# Planning Application Assessment – Delegated Report

**Planning Application Reference** : PL/2021/03311/PPFL

**Address** : Pear Tree Farm Meer End Road Meer End Solihull

**Proposal** : Replacement of an existing residential annex to Pear Tree farm.

- Proposed Plans

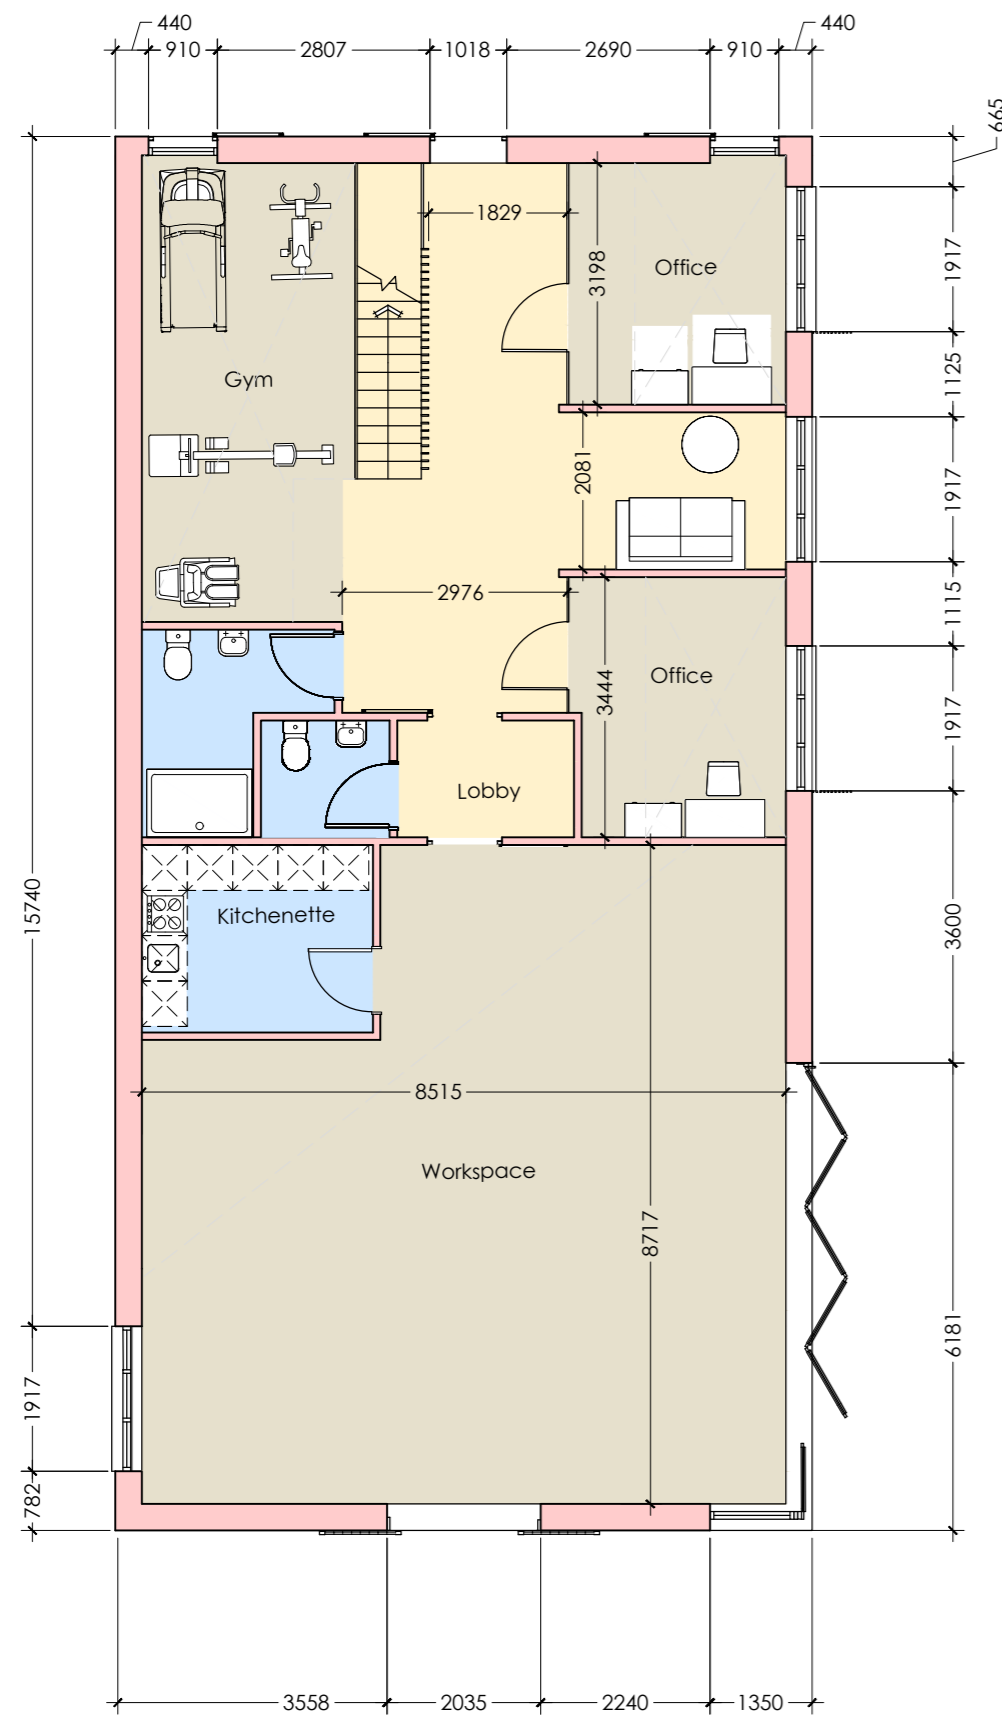
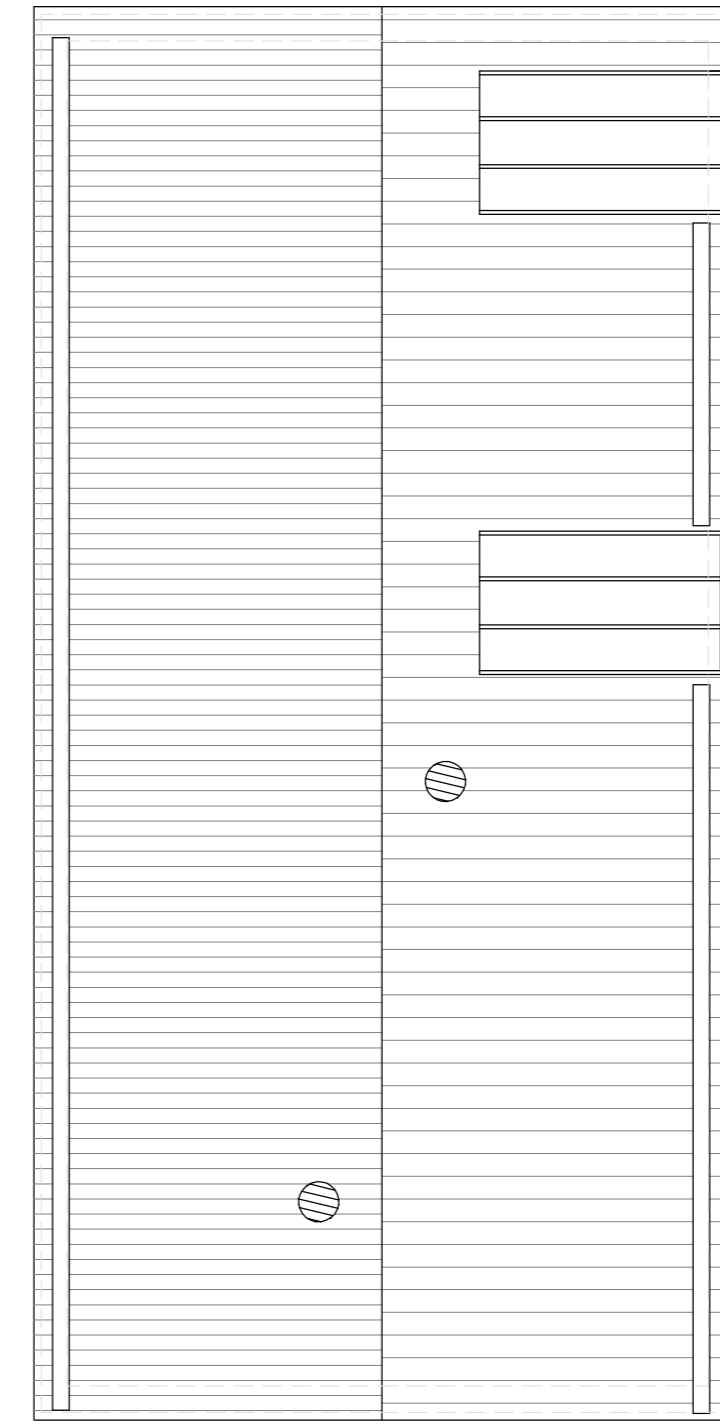
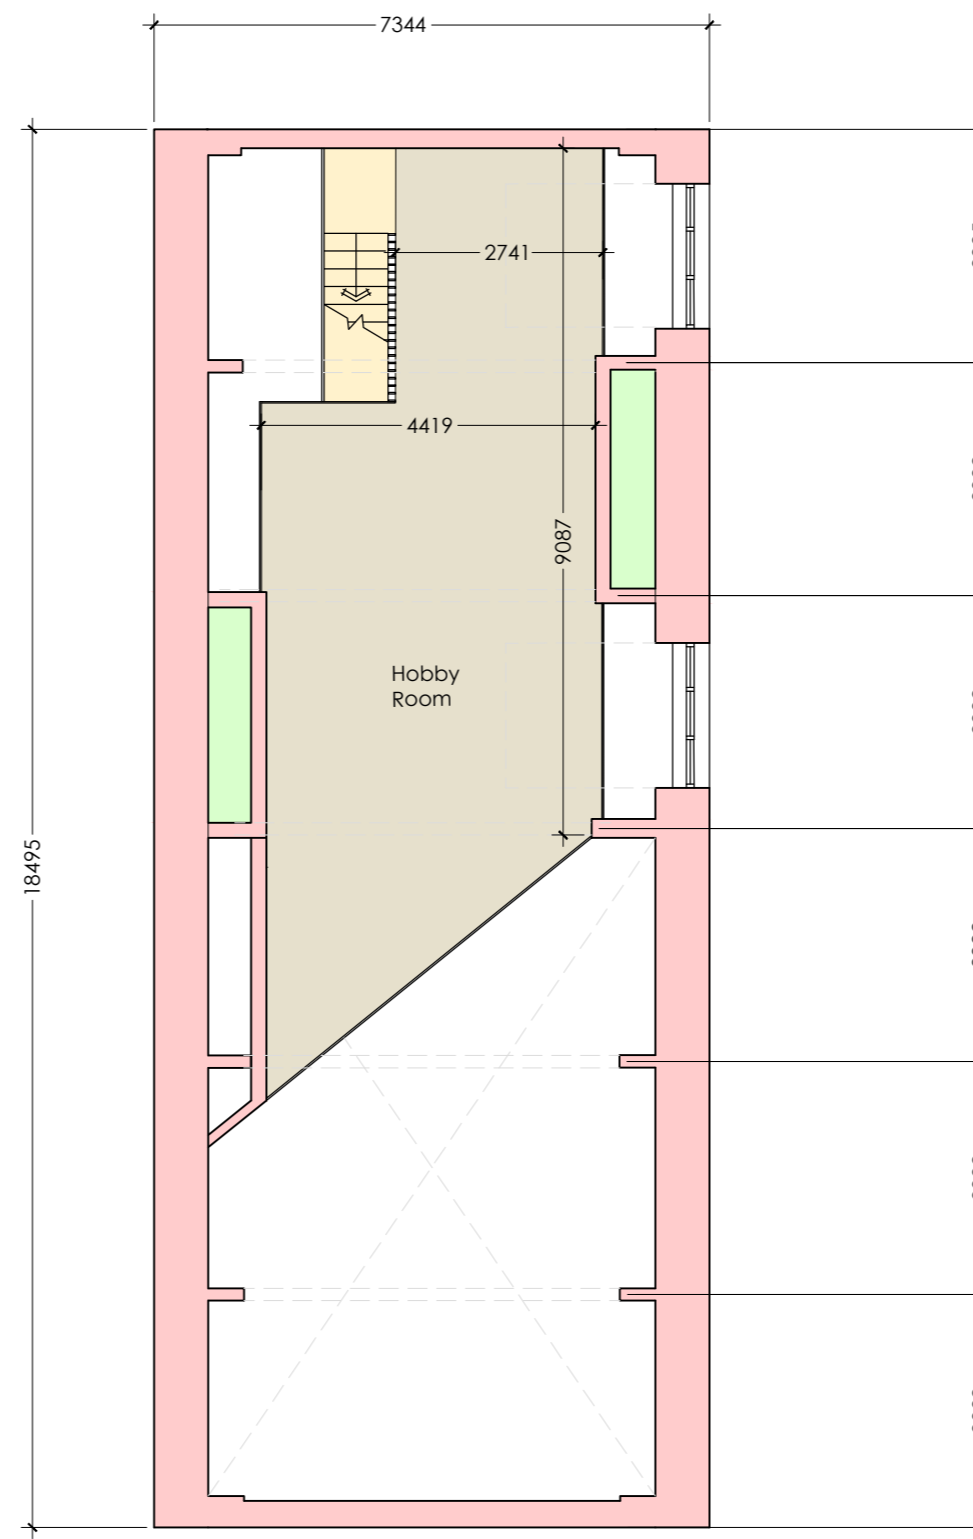
increased in size by the increase in height of the roof would result in urbanising development that will clearly be at odds with these purposes. Further the building needs to be in the same use the proposed building will ancillary habitable accommodation (the floor plan shows two toilets). Substantial weight against the proposal is therefore afforded by virtue of it constituting inappropriate development in the Green Belt and being harmful to one of the stated purposes of including land within the Green Belt.

Further the existing building is used for storage and a workshop. It has a footprint of approximately twice the size of the house and the house has other outbuildings. The use of the building for low quality domestic storage to ancillary accommodation with office /gym and two toilets indicates that it is not considered to be in the same use.
